Supporting Statement

Formation of a new 2 storey detached 2 bedroom (class C3) residential dwelling; including formation of waste storage; cycle store; parking and Amenity space for the existing and proposed dwellings

on :land at 1 Adelphi Crescent UB4 8LY

Issue – FDC/20/04/13
August /2020

PROPOSED FIRST FLOOR PLAN

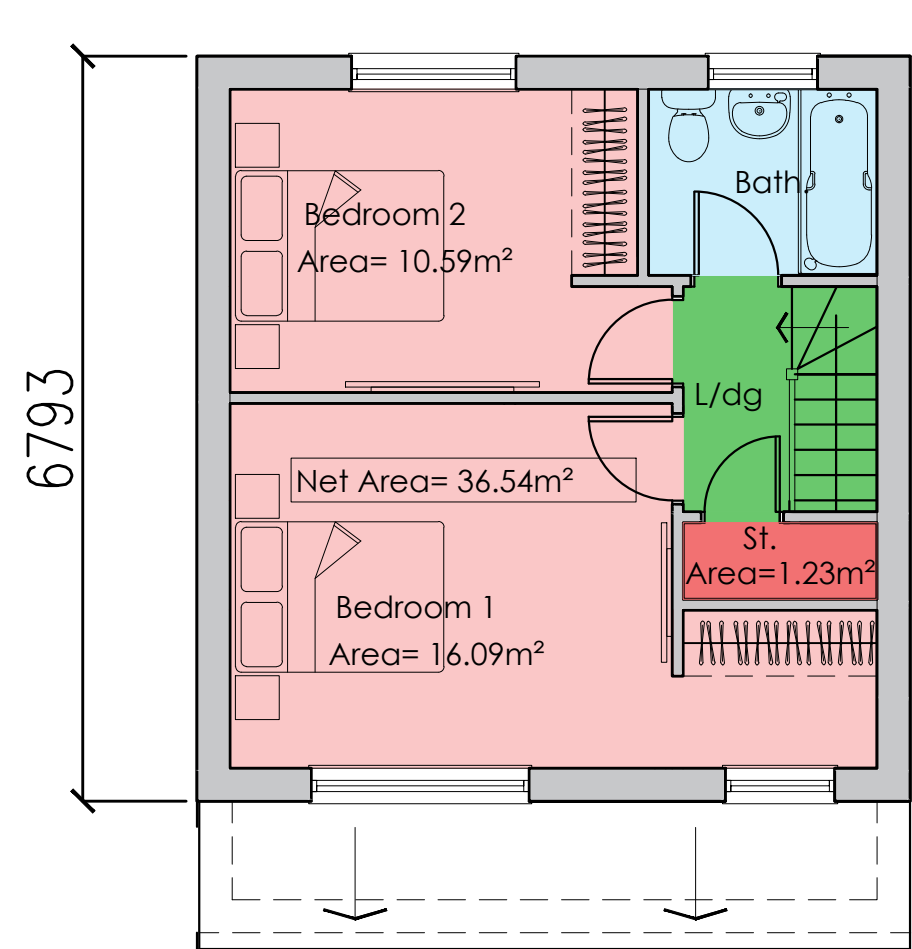
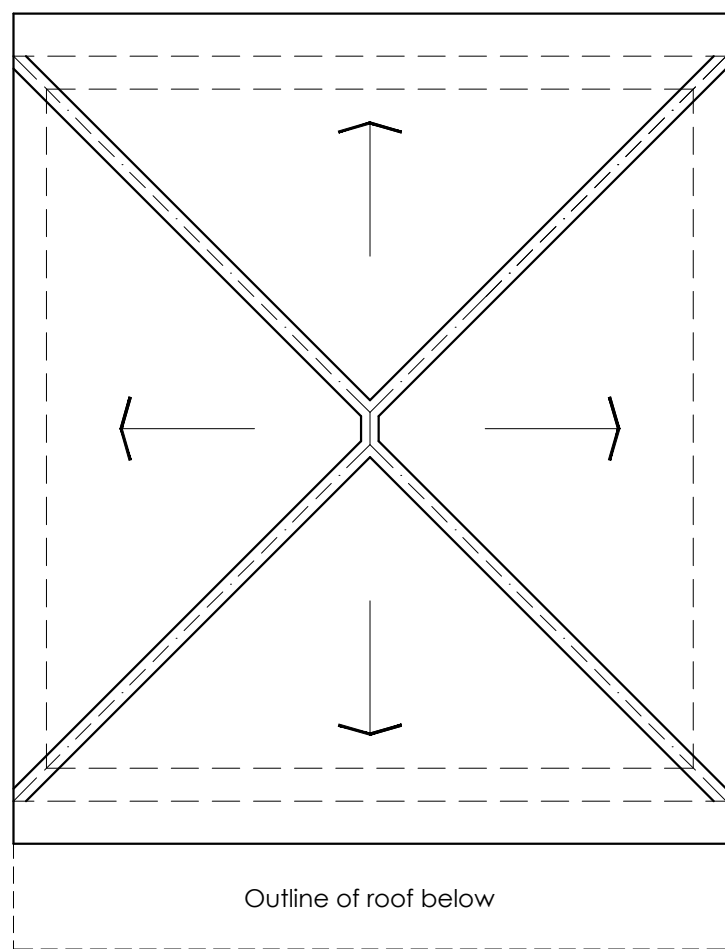
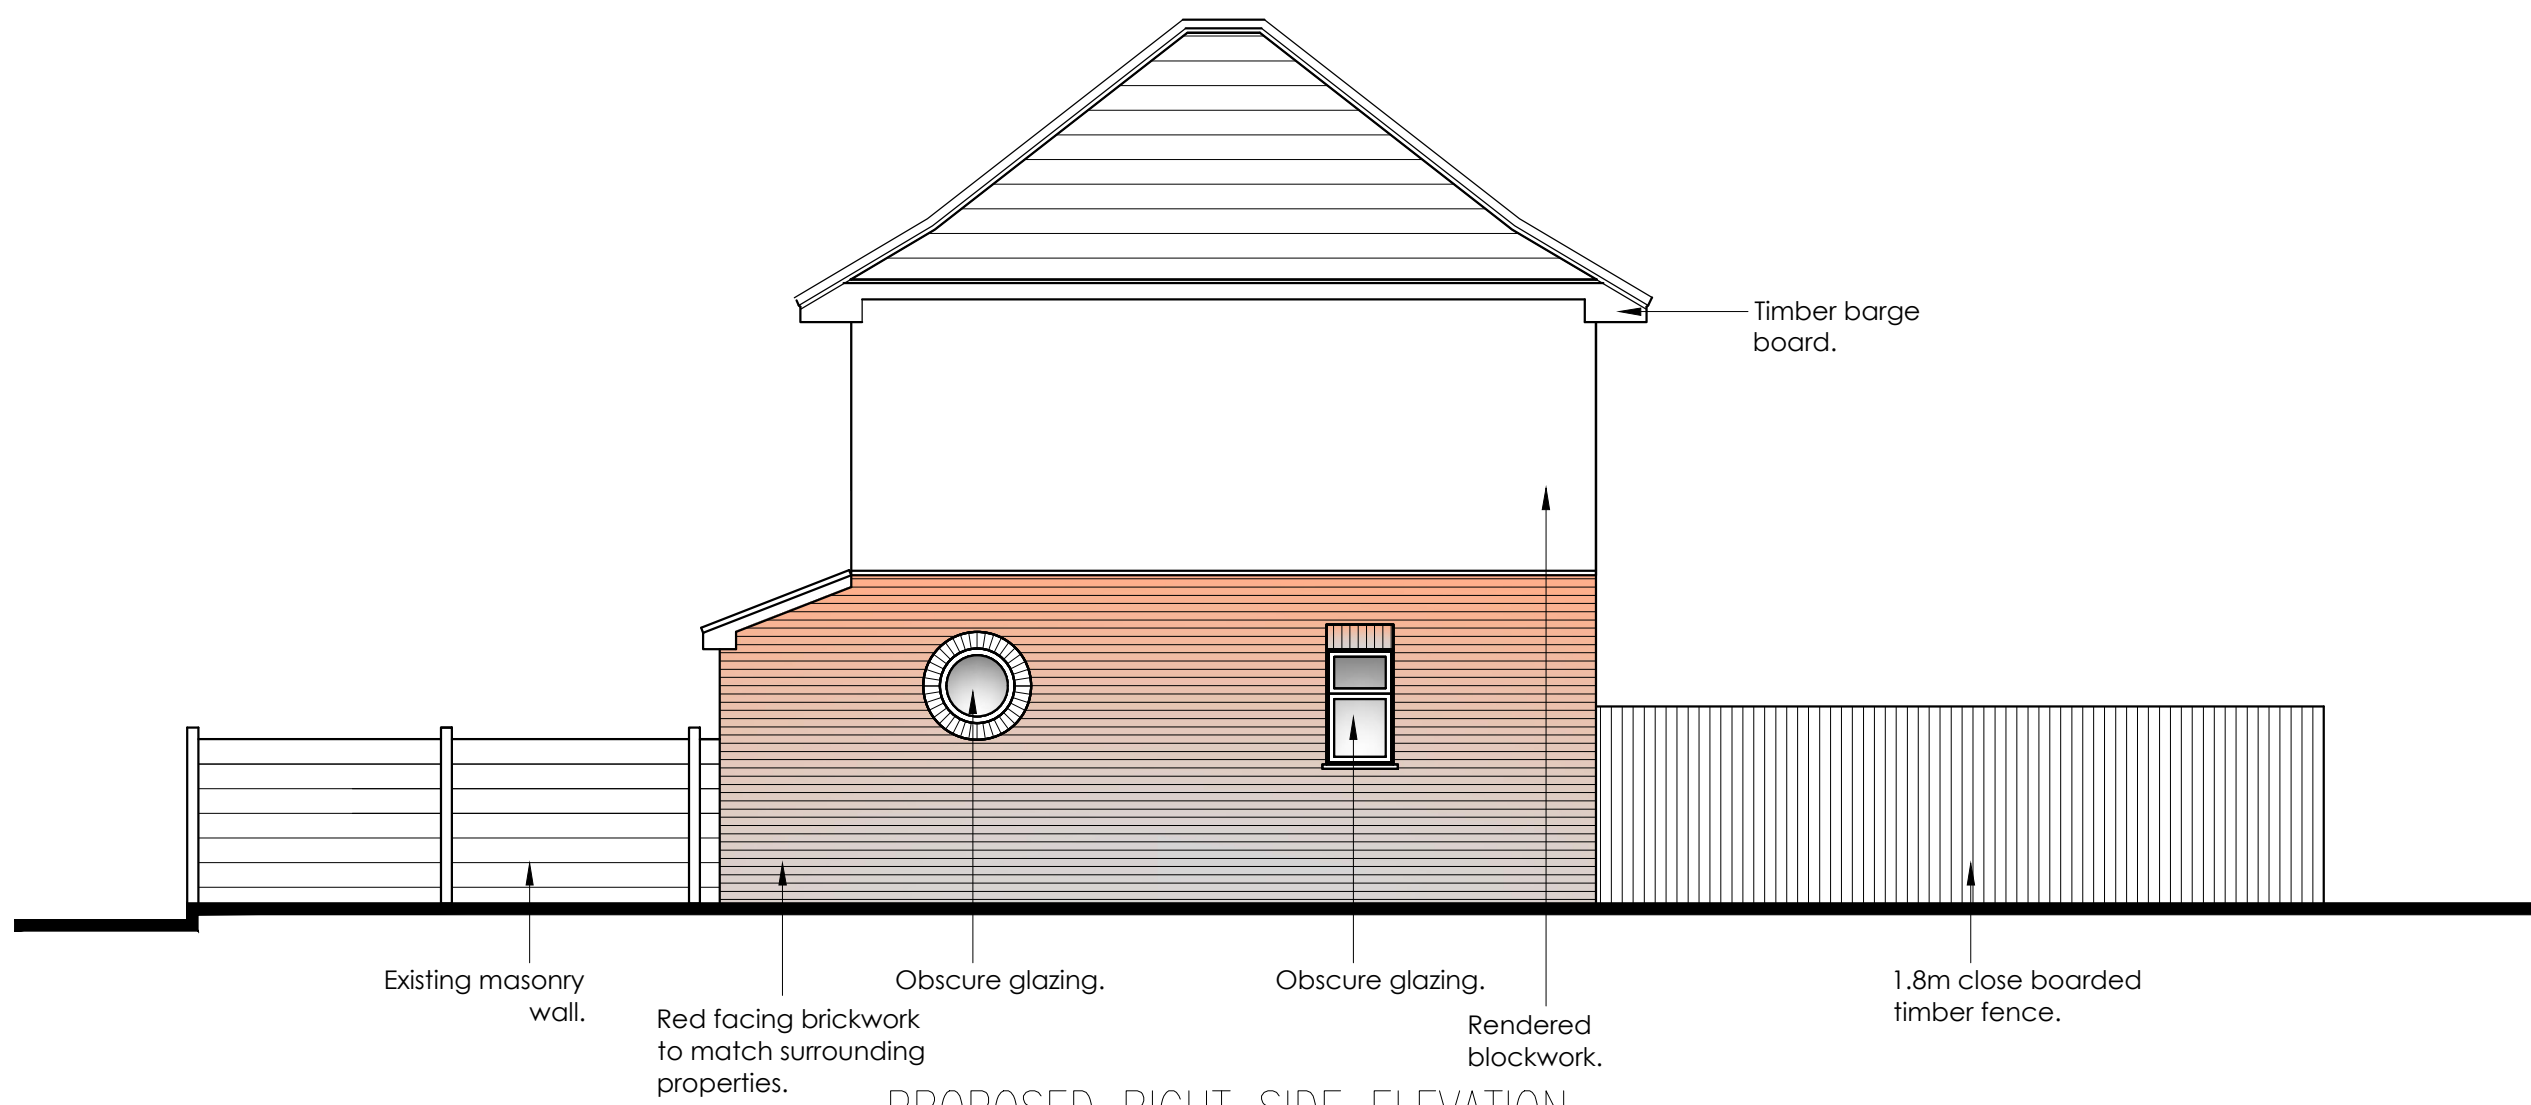
The floor area to the master bedroom has been improved to 16.09m² which is well within guidelines see drawing No: FDC/20/04/08a

4, The proposal would provide a double bedrooms of an unsatisfactory size and quality for the future occupiers of the proposed dwelling and would therefore give rise to a substandard form of living accommodation to the detriment of the amenity of future occupiers.

The size of the bedroom is in keeping with Hillington standards. If they are still not satisfied, we could omit the en-suite and make the room larger.
